3rd June 2022

RE: K/19/22/MH | Location: Flint Barn Peak Lane Kingston BN16 1RN | "Conversion of Hobby Room to Self-Contained annexe with alterations to fenestration"

REPORT - SUMMARY OF THE MATERIAL PLANNING CONSIDERATIONS

PROPOSED FLOOR PLAN + ELEVATIONS

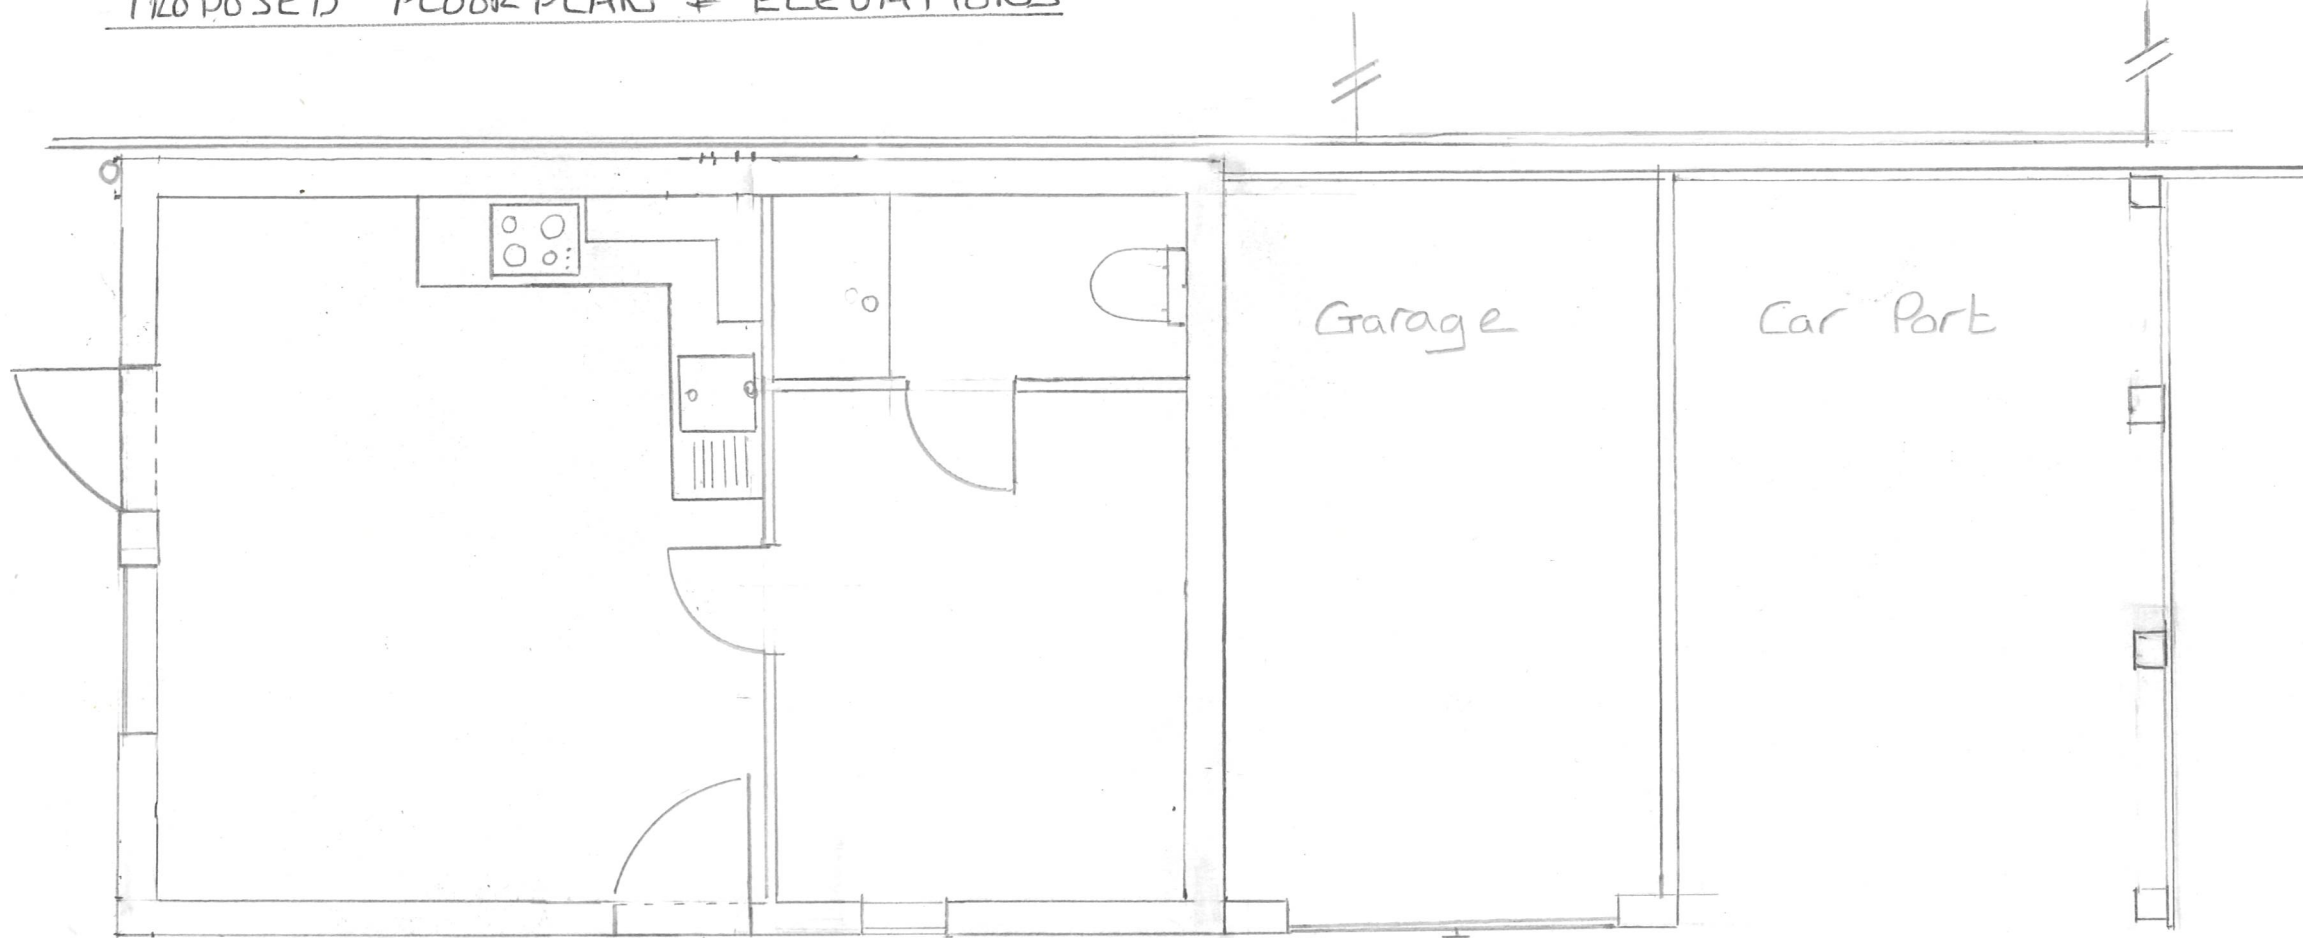
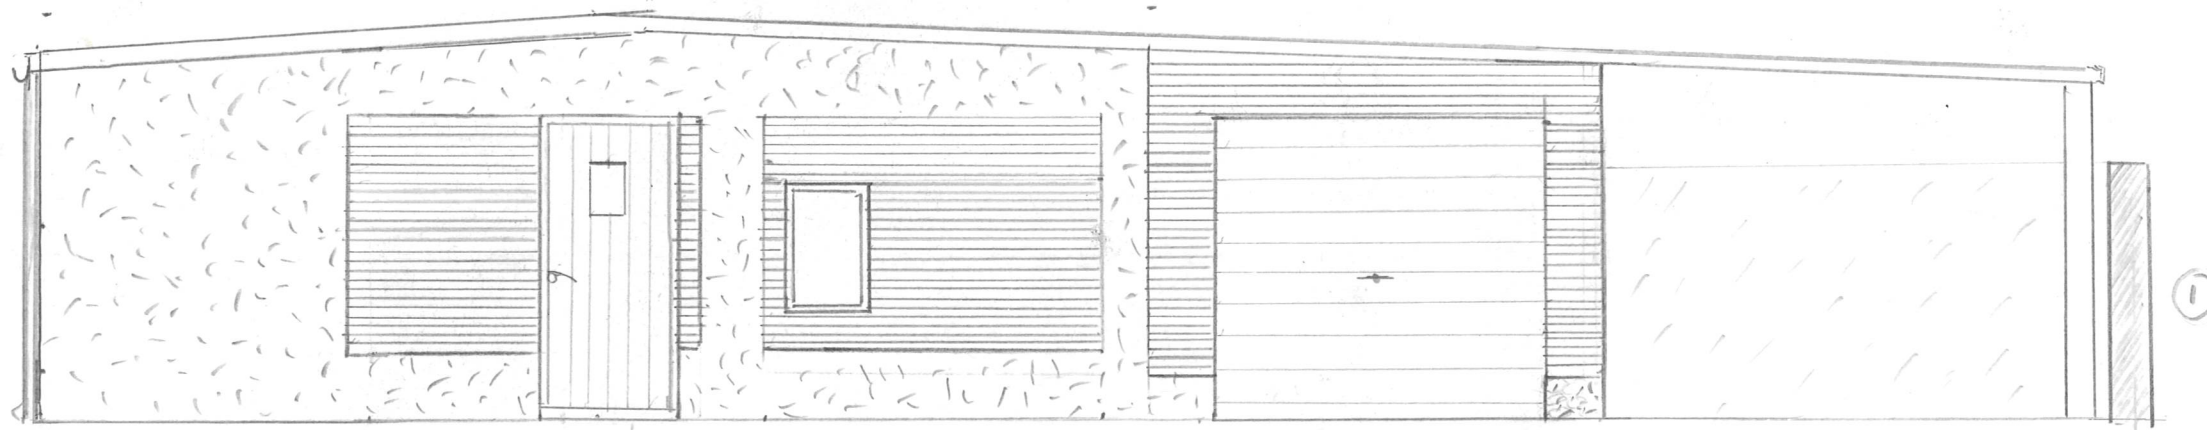
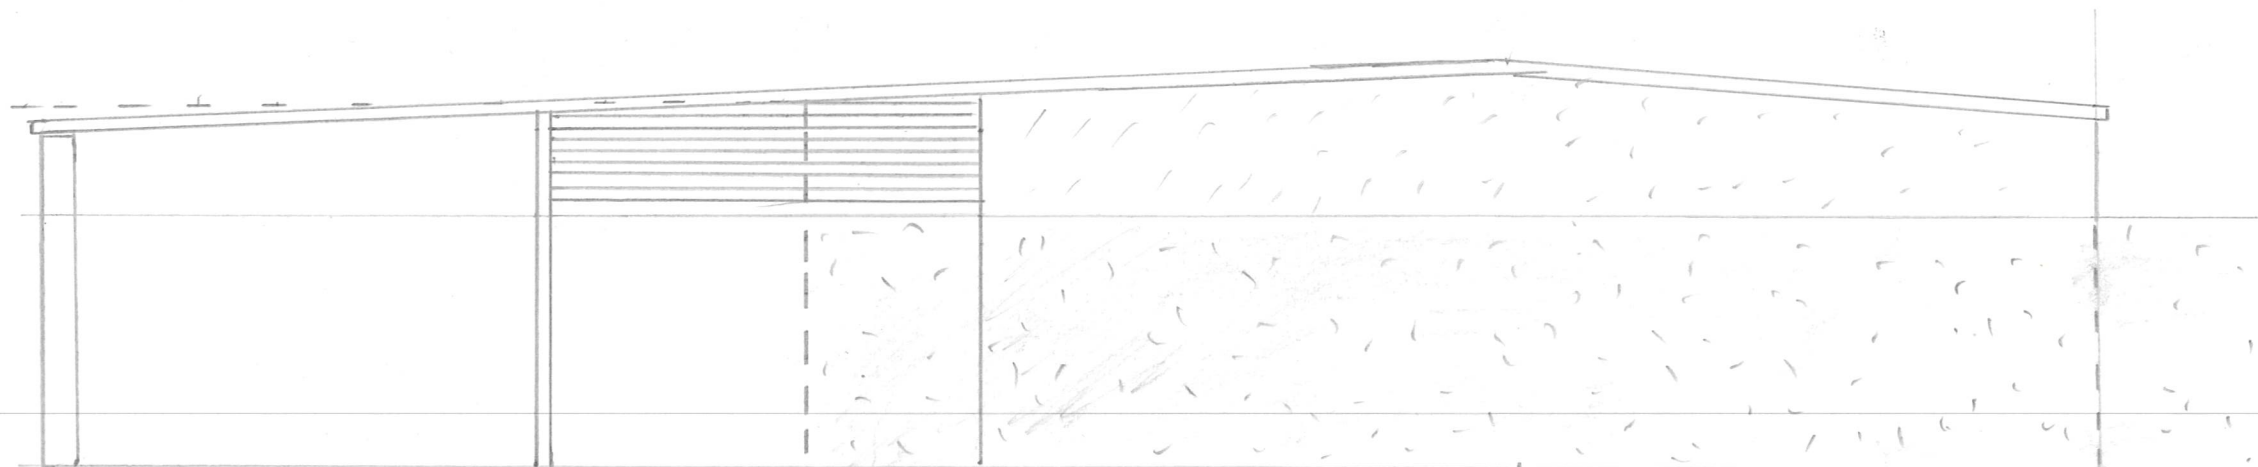
- The accommodation proposed shows a gross internal area of approx. 29m², so well the short of the adopted National standard.
 - There is no details in the application of any external amenity spaces

- a) National guidance states for 1b2p 50m², 1b1p 39m².
 - b) The application has a gross internal area of 29m and is 1b and could accommodate 2 people in the proposed bedroom, plus possibly more in the living space if it was a holiday let.

- The proposal, as it stands, does not conform with adopted Internal Space Standards and does not show storage provision.

- The proposal does not afford for flexible use and adaptation, it has low ceiling heights, potentially lower if and when insulated.
 - p.100 | Part K
 - Climate Change & Sustainability

PROPOSED ELEVATIONS

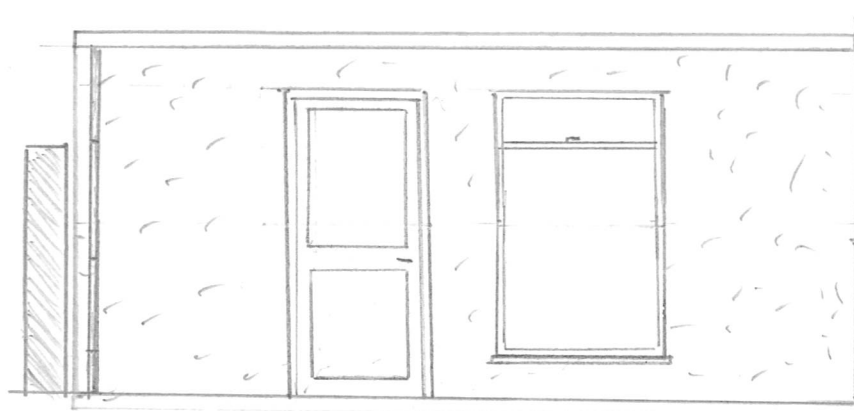
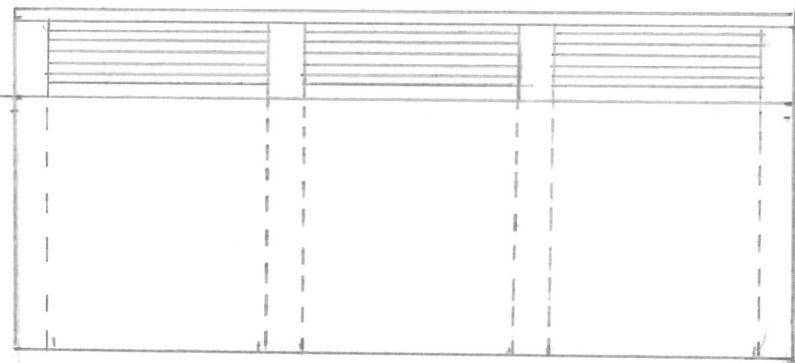
We have already evidenced a new separate service trench being installed to the garage ~~footprint~~ ¹⁹ which is a very clear indication this will not be an annexe, as described, but rather a self-contained, as described, aka separate dwelling. Additionally, further work has been undertaken in advance of obtaining permission, including installing an extractor fan, taking out a window and installing a new lintel for the door and screen to the west elevation.

- Noise e.g. shouting, partying, talking late into the night onto the terrace
- Playing music on the terrace
- Smells e.g. constant barbecuing in the summer months, and cooking smells from the extractor which has already been installed.
- Loss of privacy from sheer proximity – the garage wall is 5cm from our boundary and possibly only single skin construction.
